**Consultation Response from KC,  
Lead Local Flood Authority**

**2024/93036 Greenside Mills, Saville Road, Skelmanthorpe, Huddersfield, HD8 9EE**

**Discharge of details reserved by condition 17 (drainage) of previous outline permission  
2018/91787 for demolition of existing buildings and structures and erection of residential  
development**

**Condition 17 – Drainage Details****Further information is required.**

Title
FLOOD EXCEEDANCE
 LAYOUT

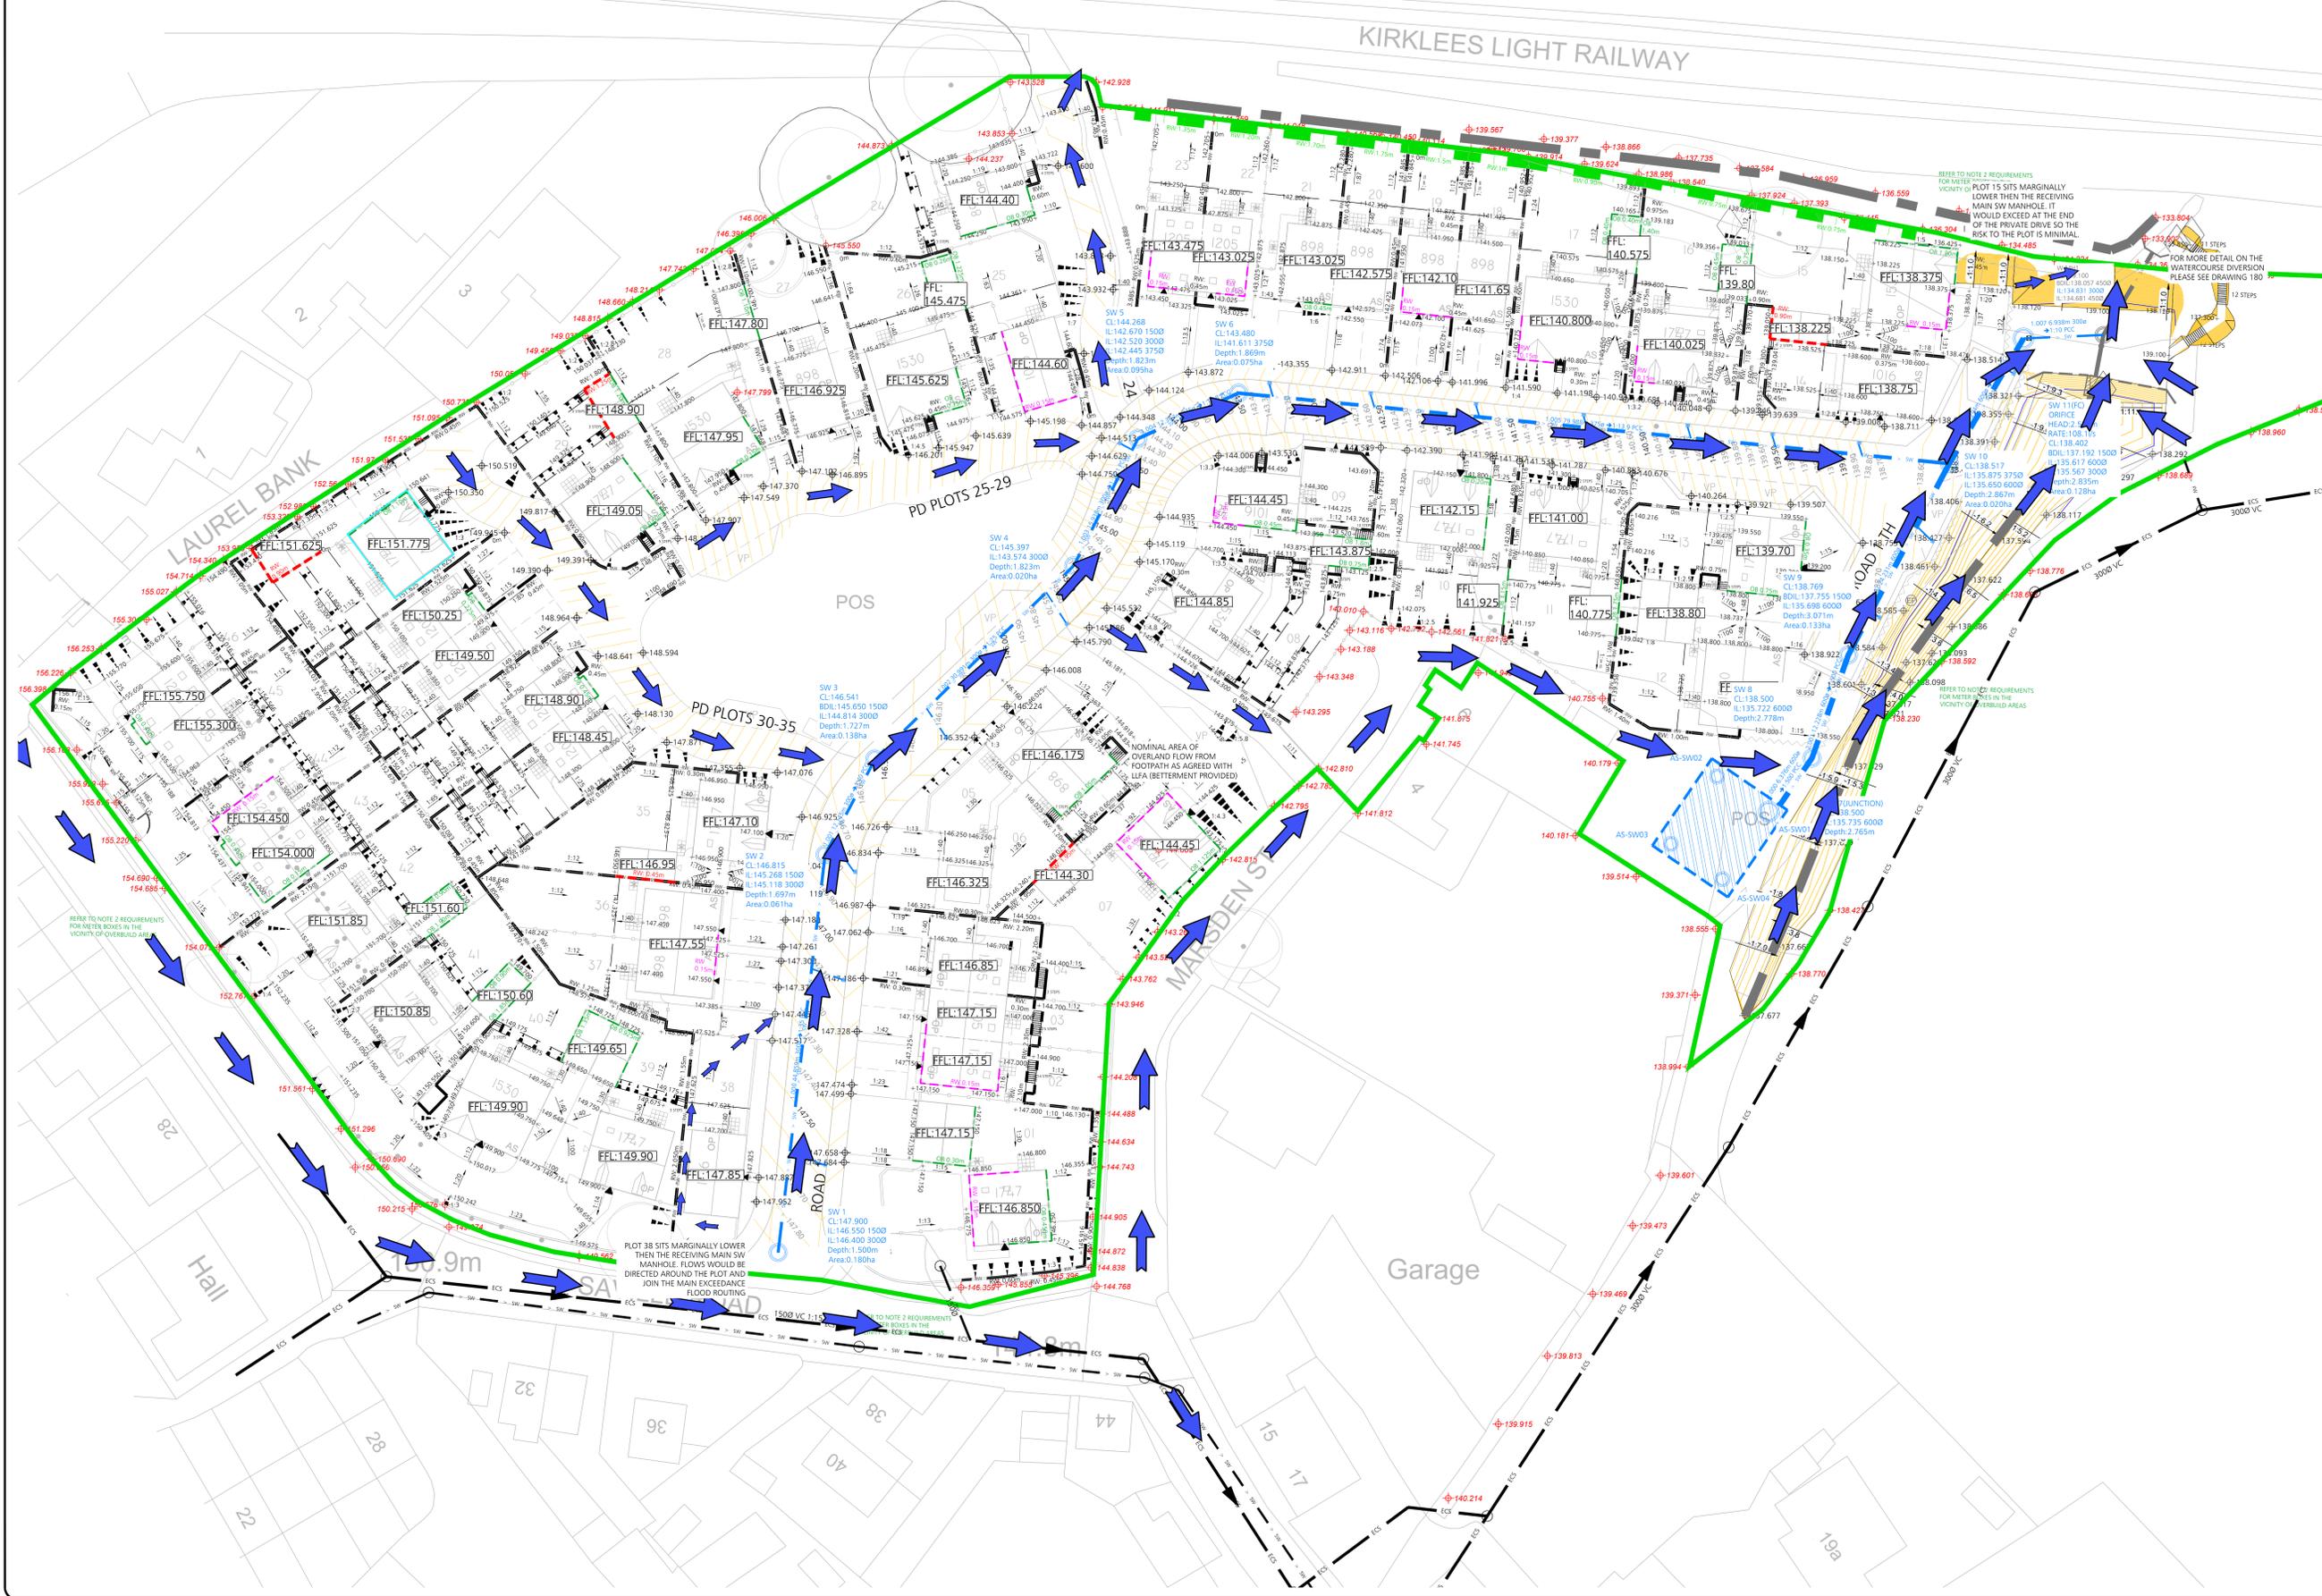
Kirklees LLFA has worked with designers and accepted the flood routing proposals submitted.

Project
LOVELL HOMES
 SAVILLE ROAD
 SKELMANTHORPE
 Title
FLOW CONTROL CONSTRUCTION
 DETAIL SW 11 (FC)

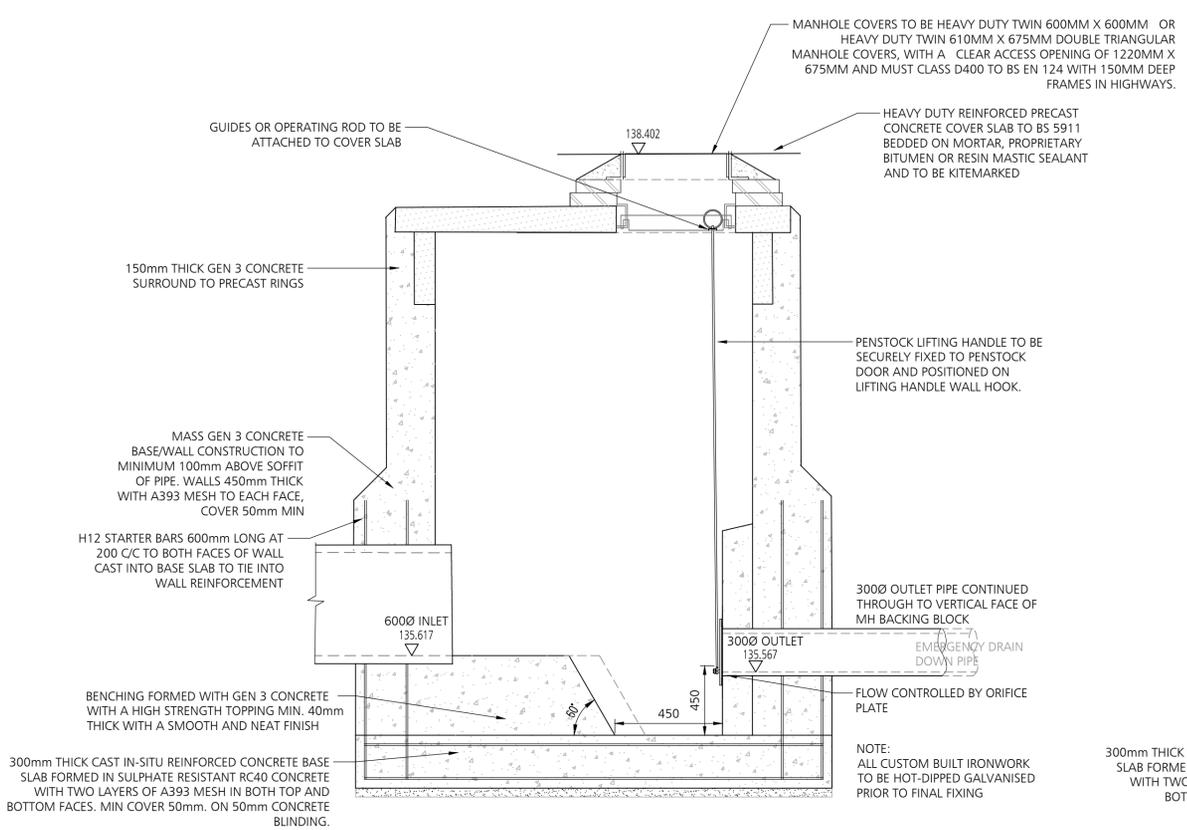
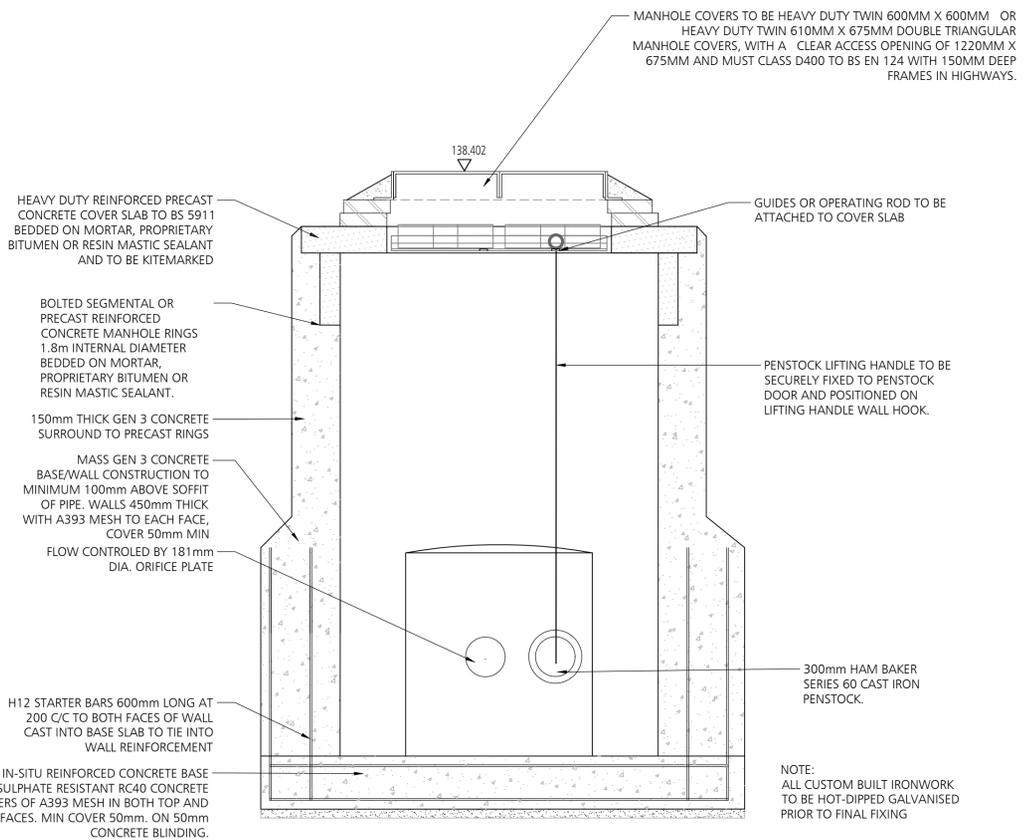
Surface water design and simulation calculations are required to support this application. This should include sizing of the orifice plate in relation to the discharge rate.

Title
**PROPOSED IMPERMEABLE AREA
PLAN**

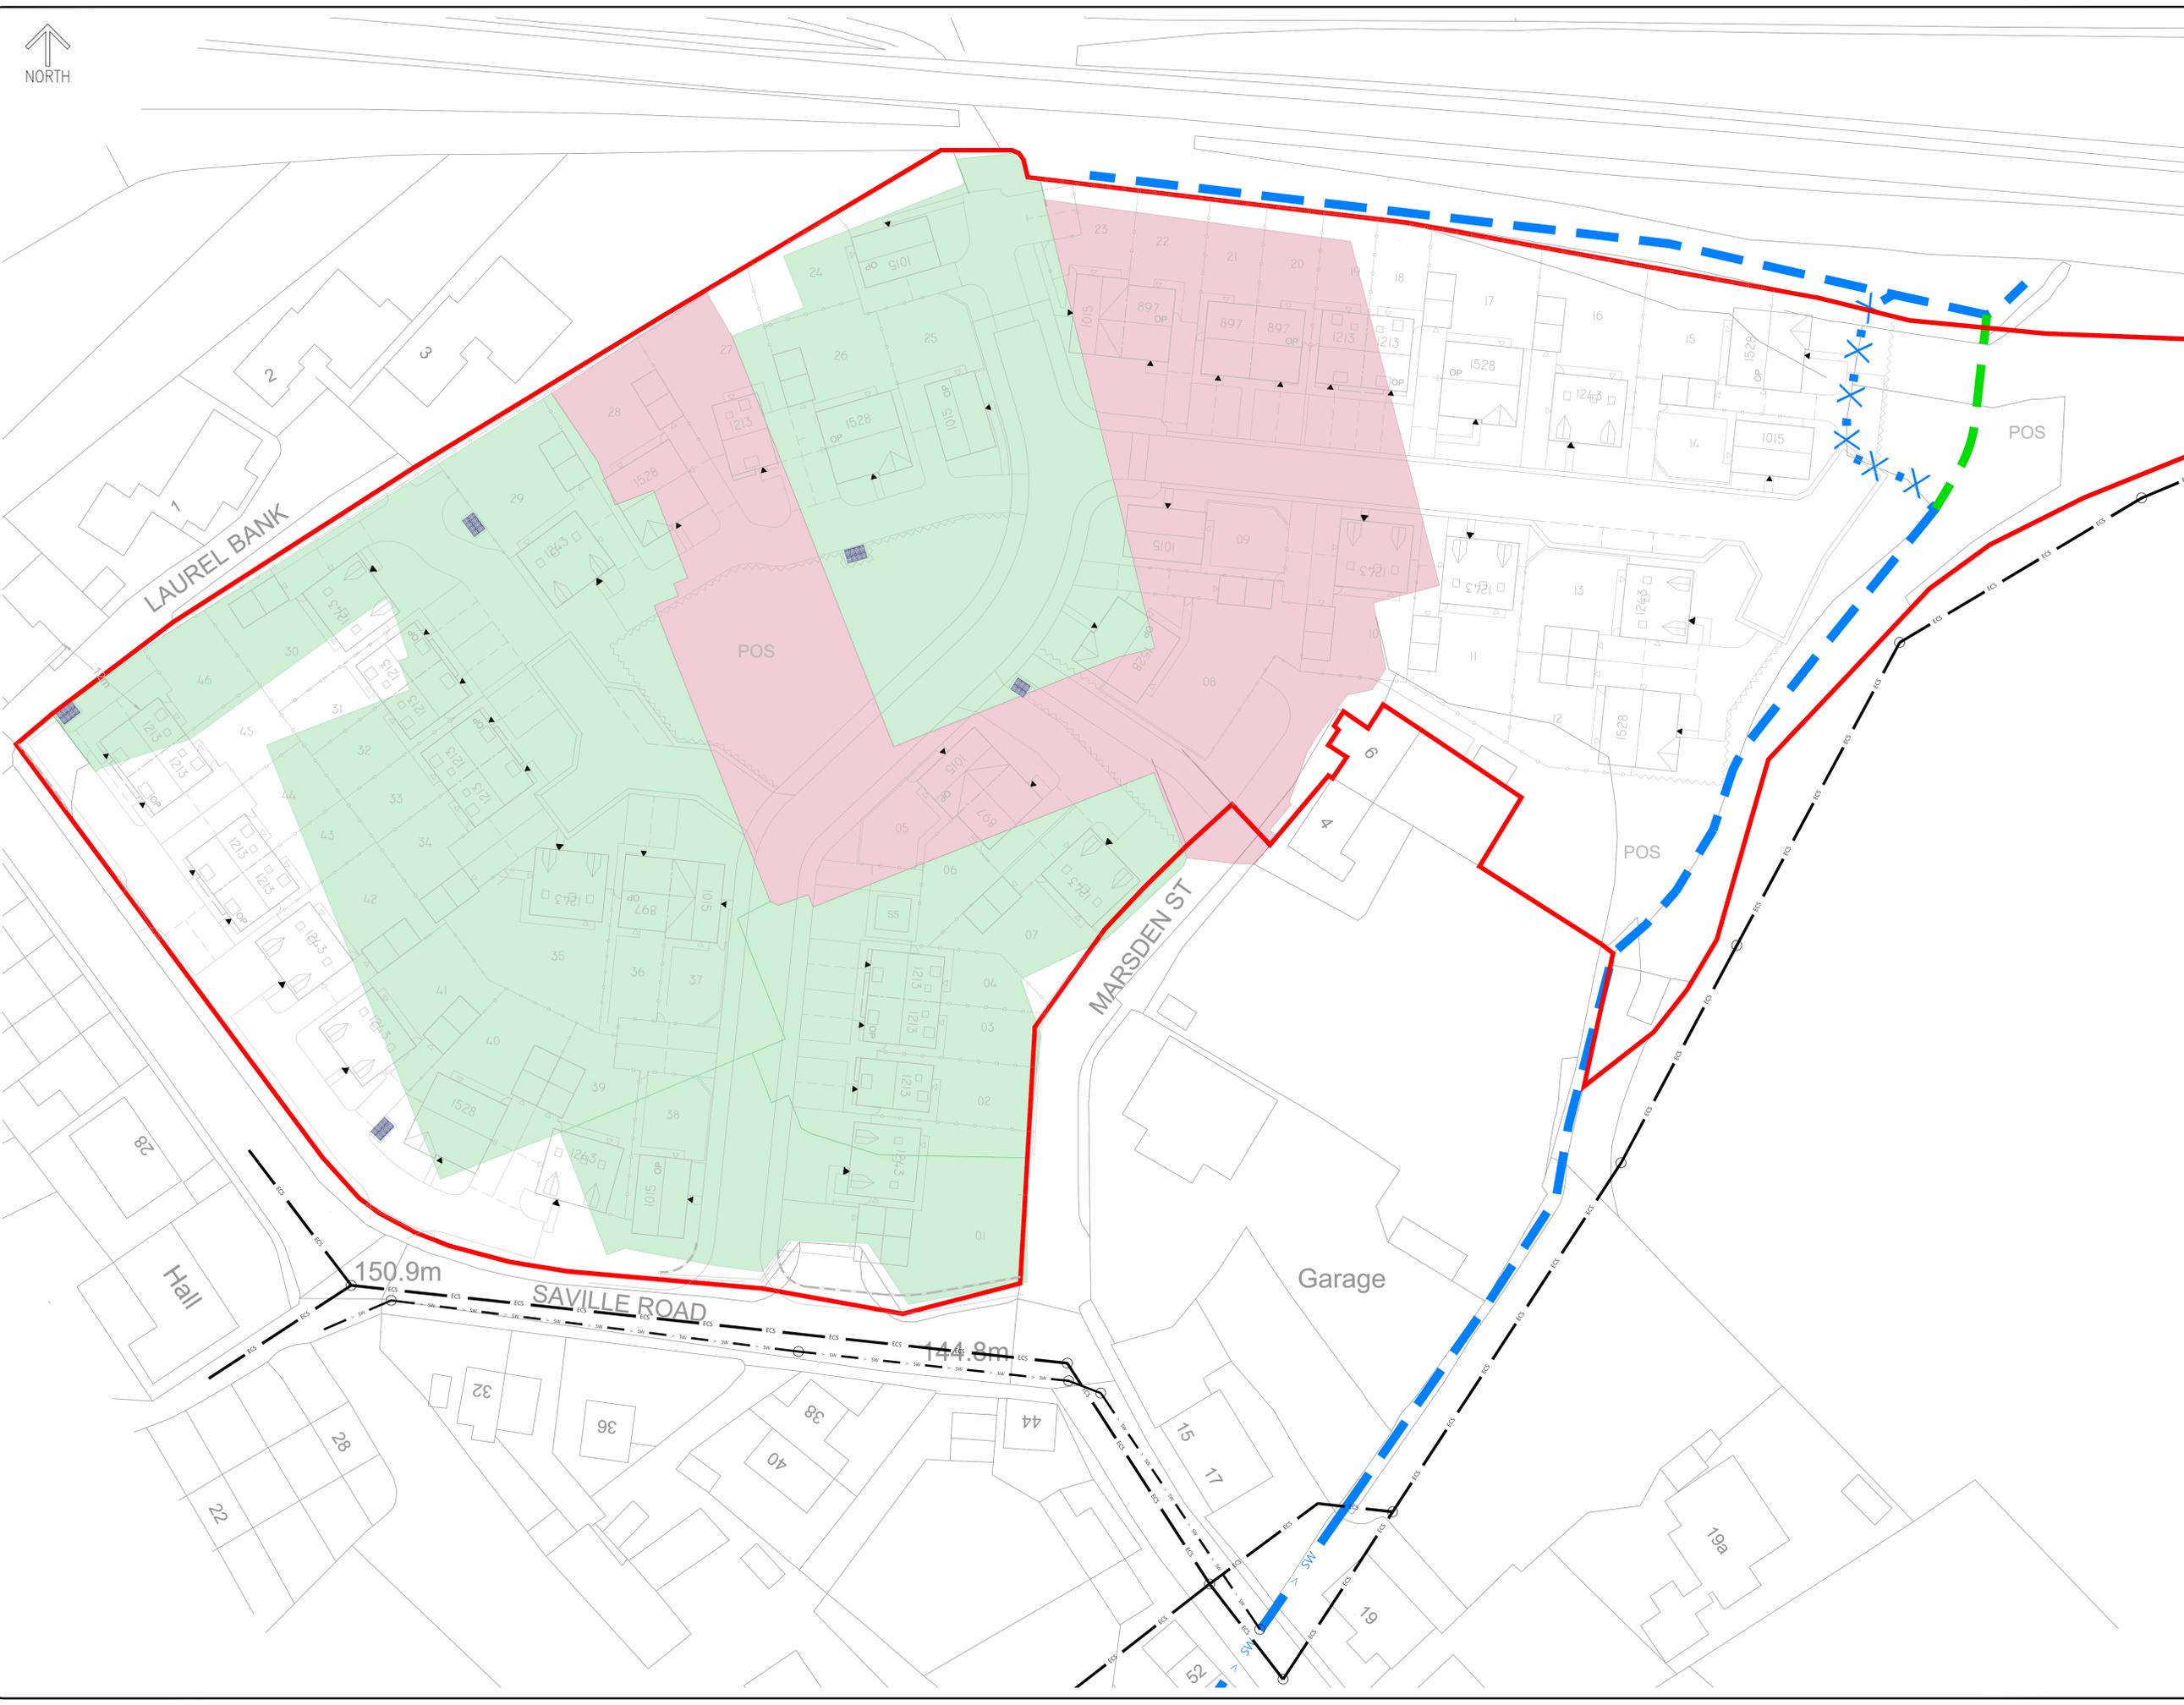
We note the submission of impermeable area drawings.
